City of Portland, Maine - Building or Use Permit Application
 389 Congress Street, 04101 Tel: (207) 874-8703, Fax: (207) 874-8716

Permit No: 06-0363	Issue Date:	CBL: 029 A00103A
------------------------------	--------------------	----------------------------

Past Use: Residential / Condo	Proposed Use: Residential / Condo raise 8ft ceilings to 10ft ceiling in kitchen, living room and hallway	Permit Fee: \$30.00	Cost of Work: \$900.00	CEO District: 1
Proposed Project Description: Raise 8ft ceilings to 10ft ceiling in kitchen, living room and hallway		FIRE DEPT: <input type="checkbox"/> Approved <input type="checkbox"/> Denied	INSPECTION: Use Group: Type	
		Signature:	Signature:	
PEDESTRIAN ACTIVITIES DISTRICT (P.A.D.)				
Action <input type="checkbox"/> Approved <input type="checkbox"/> Approved w/Condition <input type="checkbox"/> Denied				
		Signature:	Date:

Floor Plan with walls removed

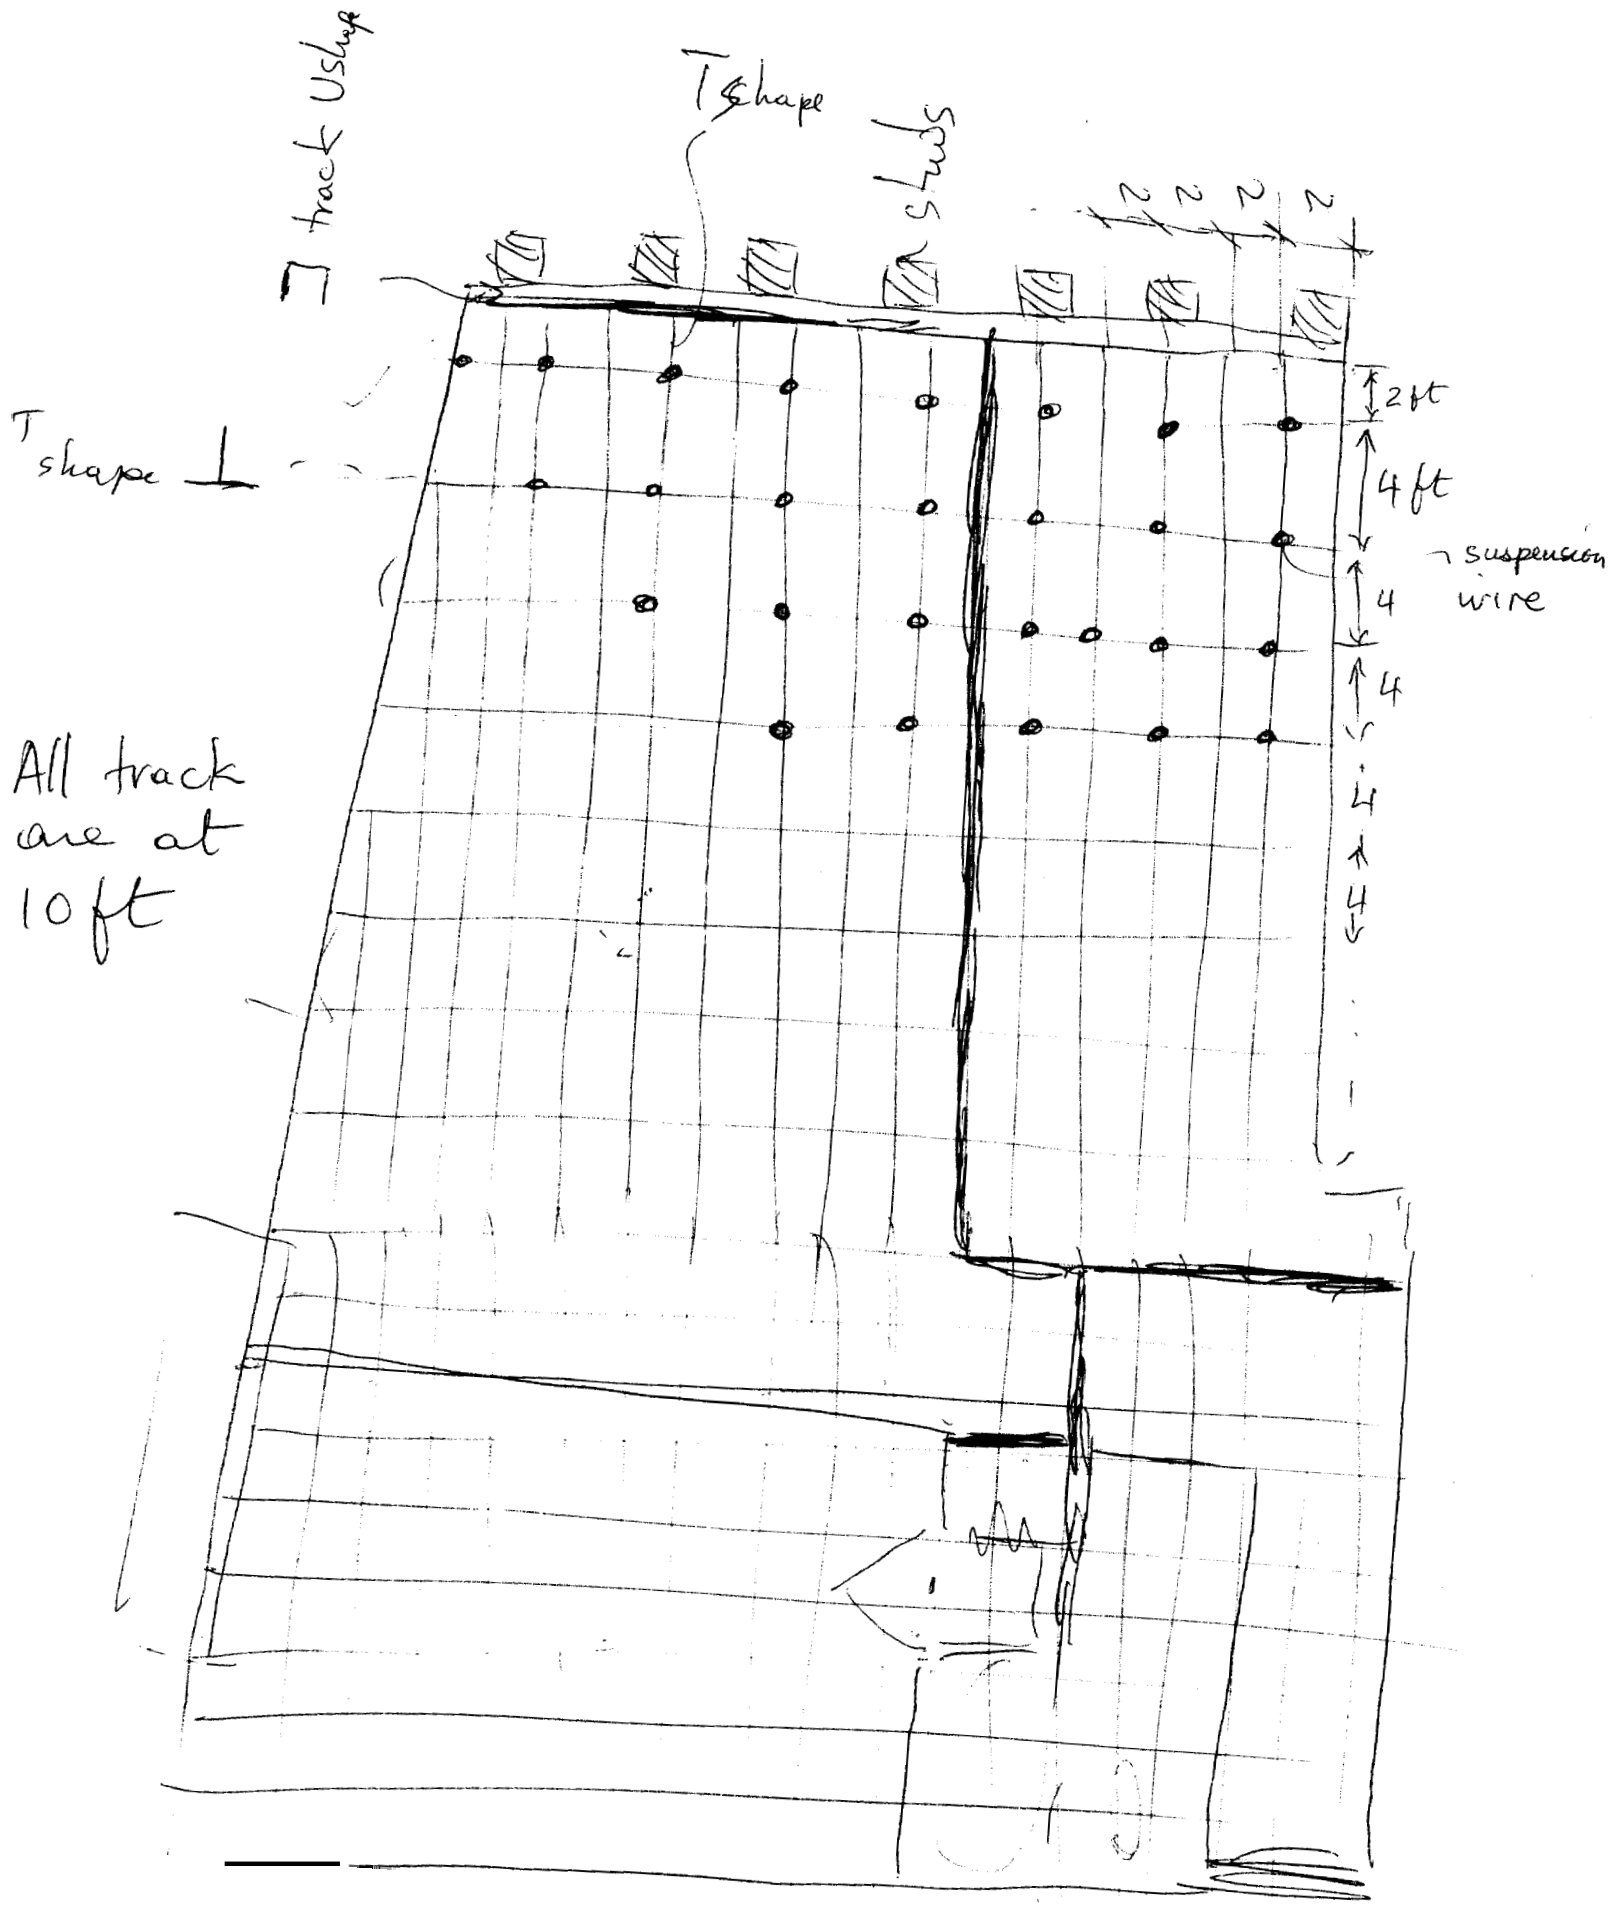
Comments:
3/29/2006-mjn: left message w/ applicant, plans lack construction details, fire rating etc
